EPC DPW Stormwater-GEC Checklist Comments.pdf Markup Summary

: PPR2619

DMC RESPONSE: Number added

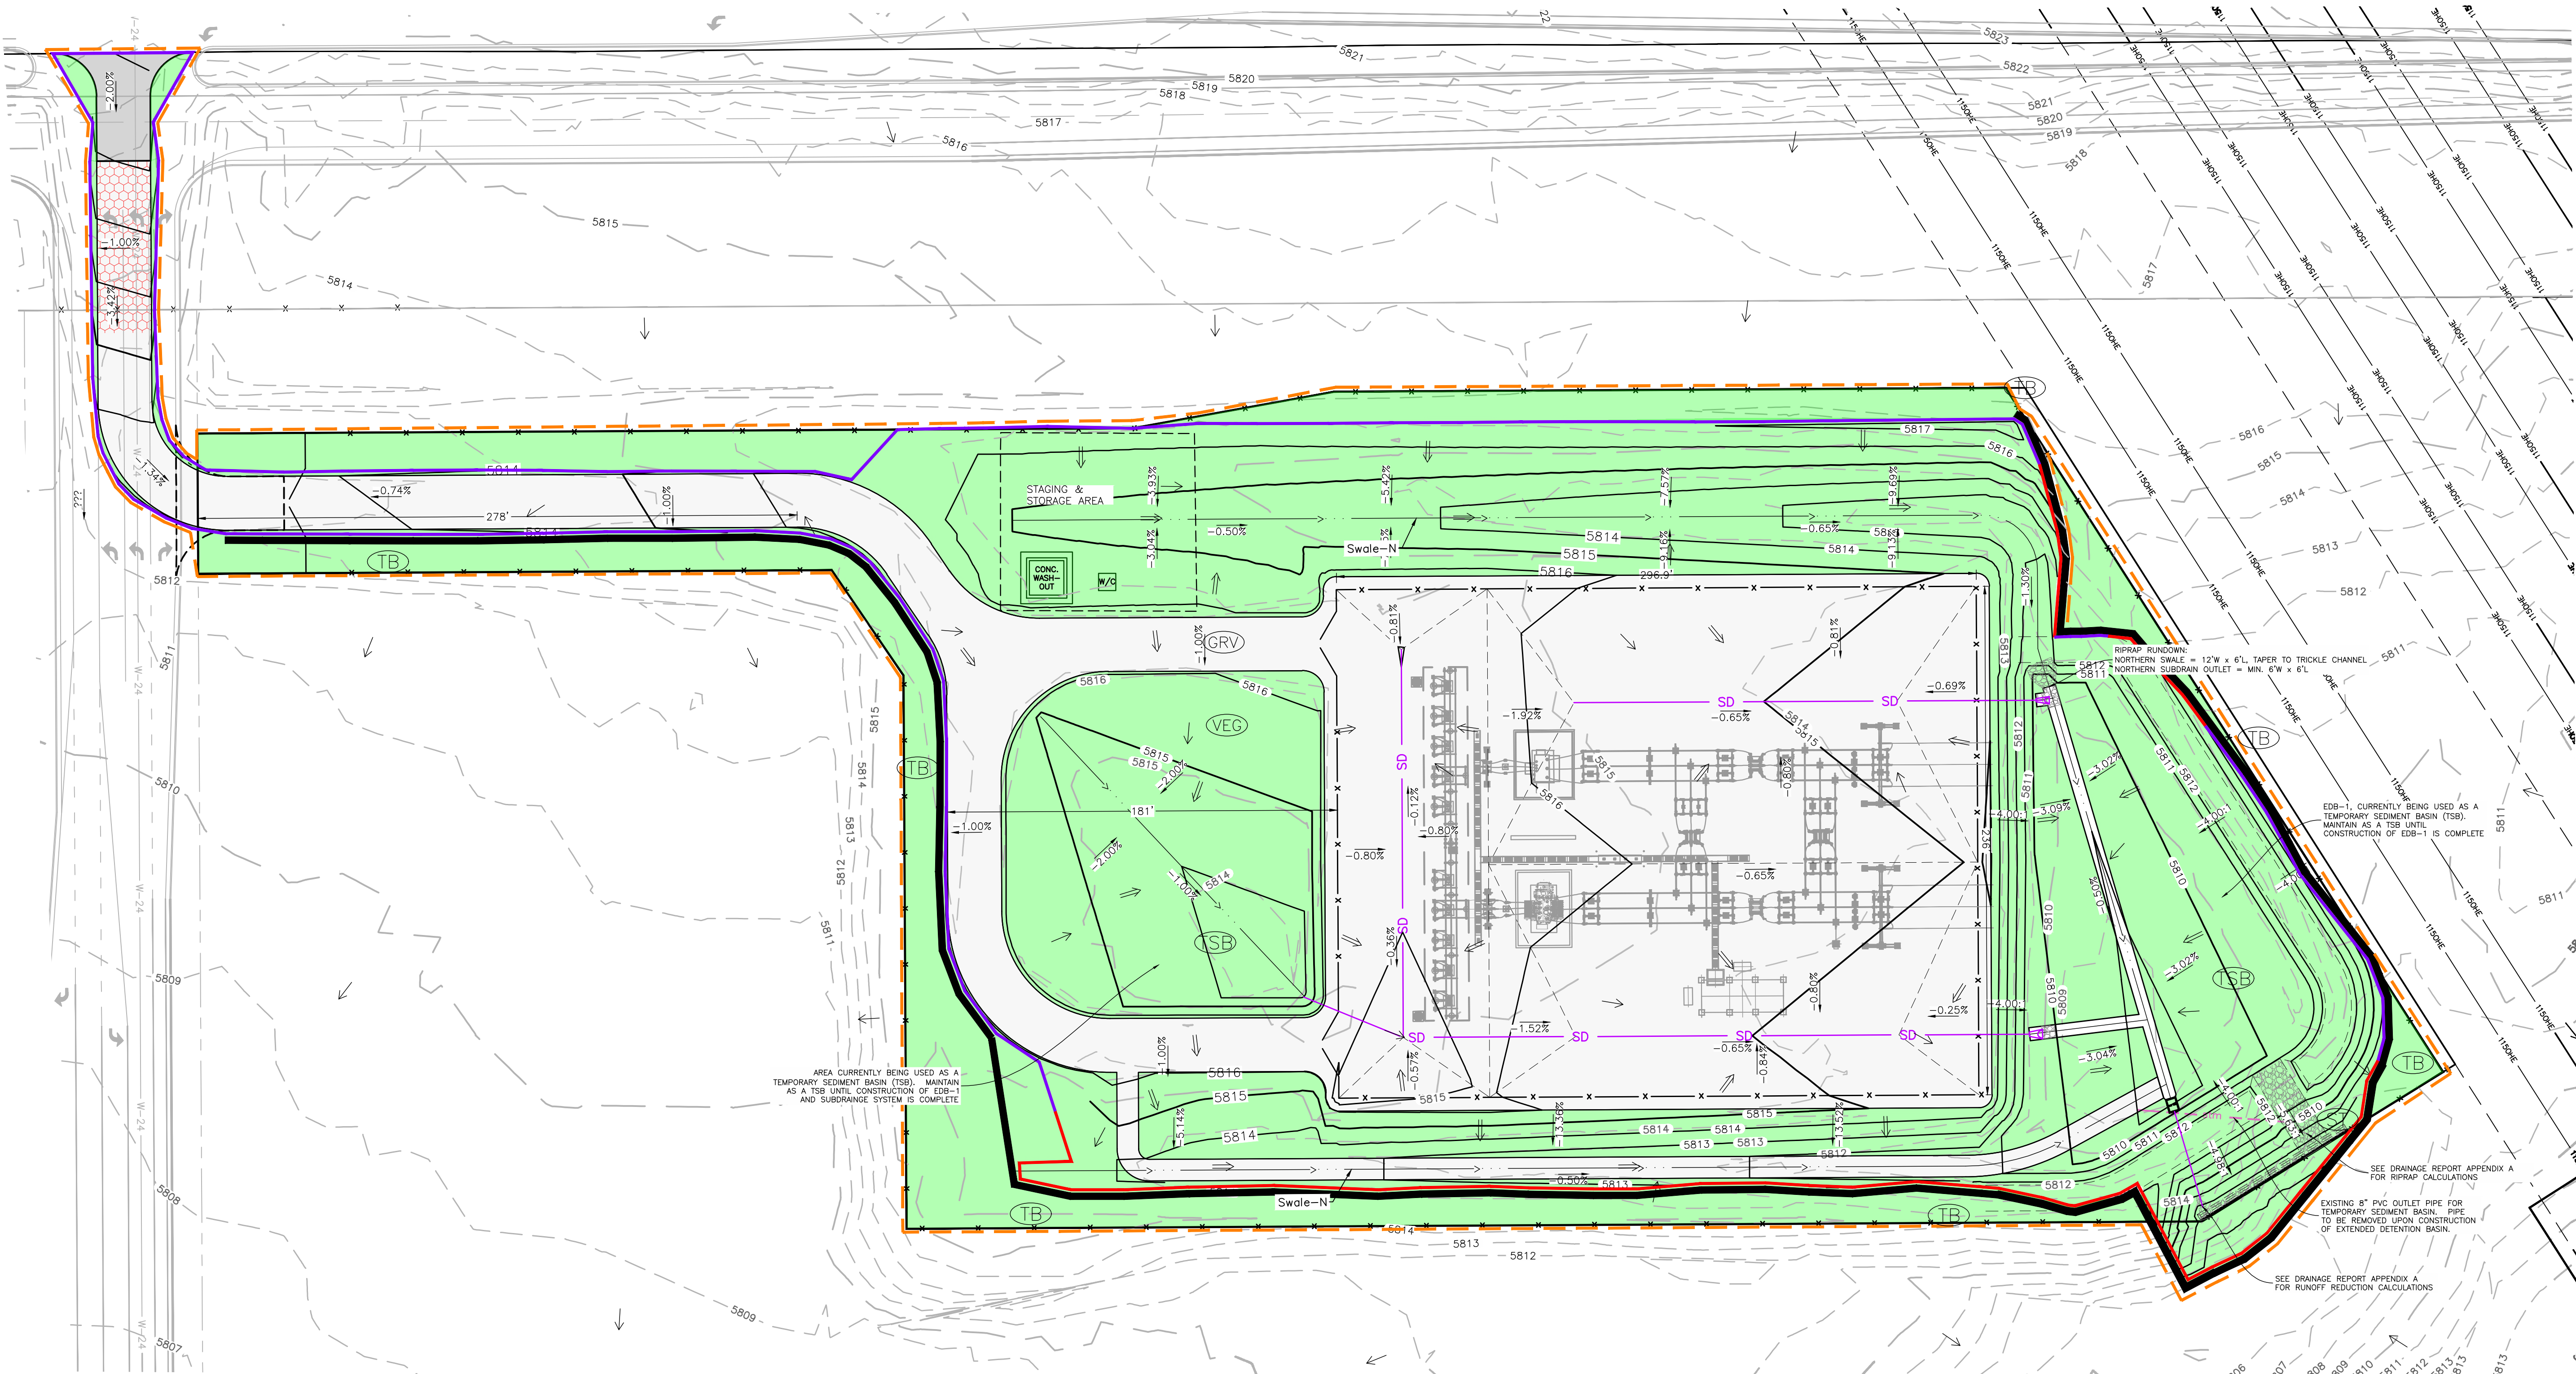
Details for all proposed temporary construction control measures to include information on dimensions, installation, materials, and maintenance requirements. Custom or other jurisdiction's details used must meet or exceed EPC standards

DMC RESPONSE: Additional details have been included in plans to account for existing BMPs as well as BMPs included in latest plans
